Application No: LU/310/18/PL

Recommendation Report for Planning Permission

LOCATION: 1 Arcade Road
Littlehampton
BN17 5AP

PROPOSAL: Addition of first floor to form self-contained flat, change of use of existing leisure use (D2 Assembly & Leisure) to office use (A2 Financial & Professional Services) at ground floor & external alterations.

SCALE / 1:100 + 1:50 @ A3
 DATE / 06.10.2018
 DWG. NO / 021018 / TP.02'A

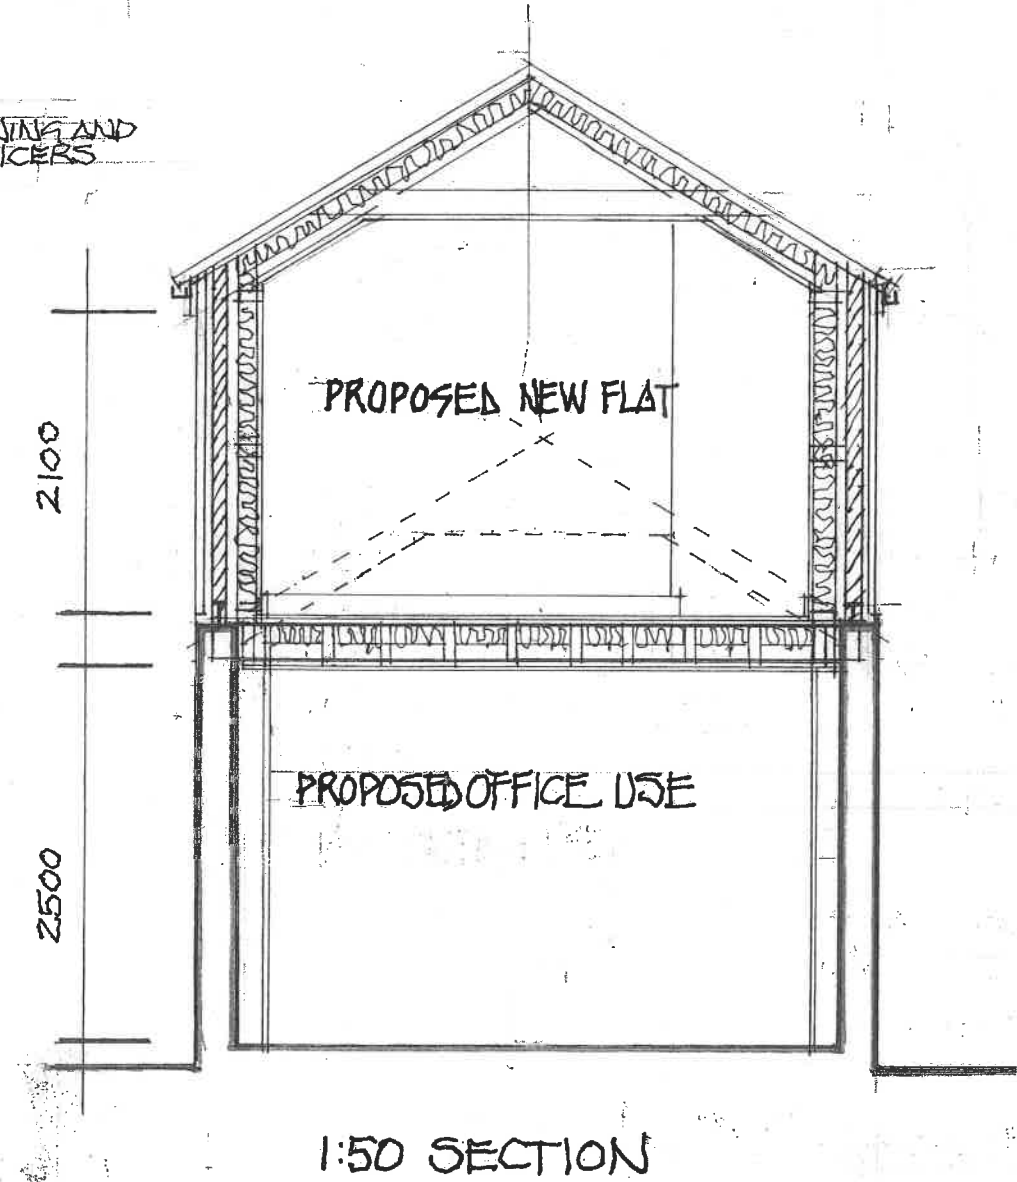
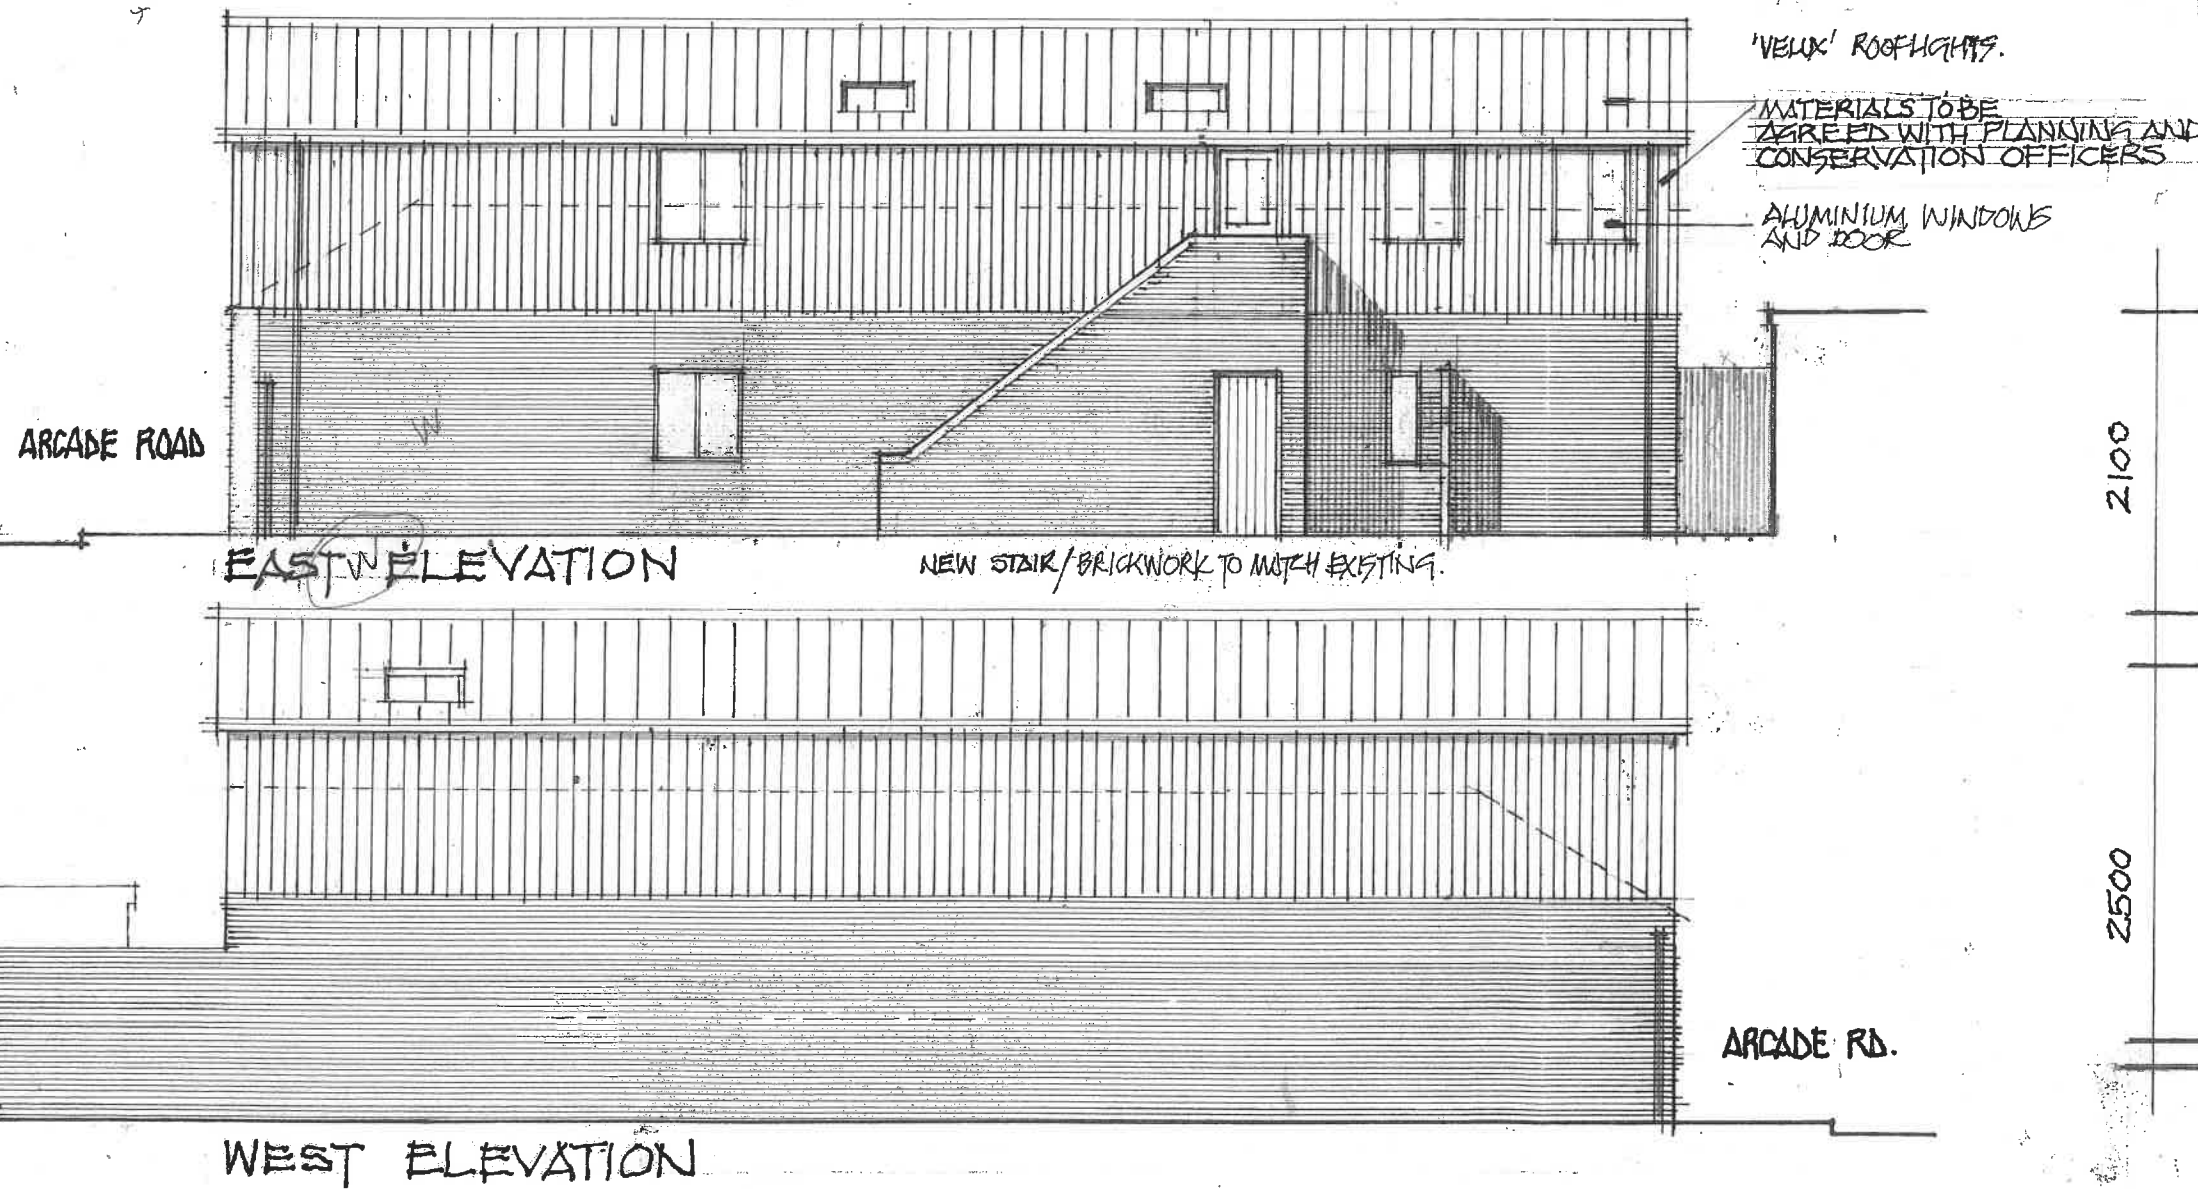
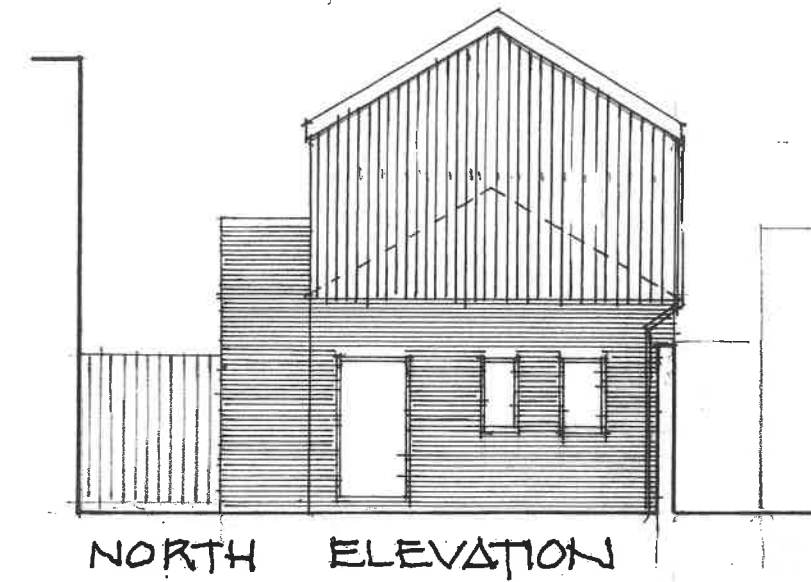
enhance the appearance of the building, but the current proposal does not demonstrate that the material will reflect the character of buildings found in the local area.

The proposed profiled steel cladding to the roof and elevations which are indicated on the elevation plans would detract from the traditional materials used on neighbouring properties and it is therefore proposed to condition these materials to ensure that the development enhances the area and does not detract from the appearance of the street scene nor the setting of the Arcade a Locally Listed Building. The extension would be readily visible given its position on the road frontage but it is in keeping with the height of adjacent development and therefore the scale and character of the area. Together with the conversion of the ground floor it would accord with policies DSP1, DDM1, DDM4 (a) and (e) of the Local Plan and Littlehampton Neighbourhood Plan Policies 1 and 2.

The concerns of the Conservation Officer are being addressed by the deletion of the reference to materials on the elevation plans and the imposition of a materials condition. The provision of the balcony is a positive feature in terms of the external amenity space it provides.

- 2 The development hereby approved shall be carried out in accordance with the following approved plans:
Site Location and Floor Plans 021018/TP.01
Elevations 021018/TP.02A.
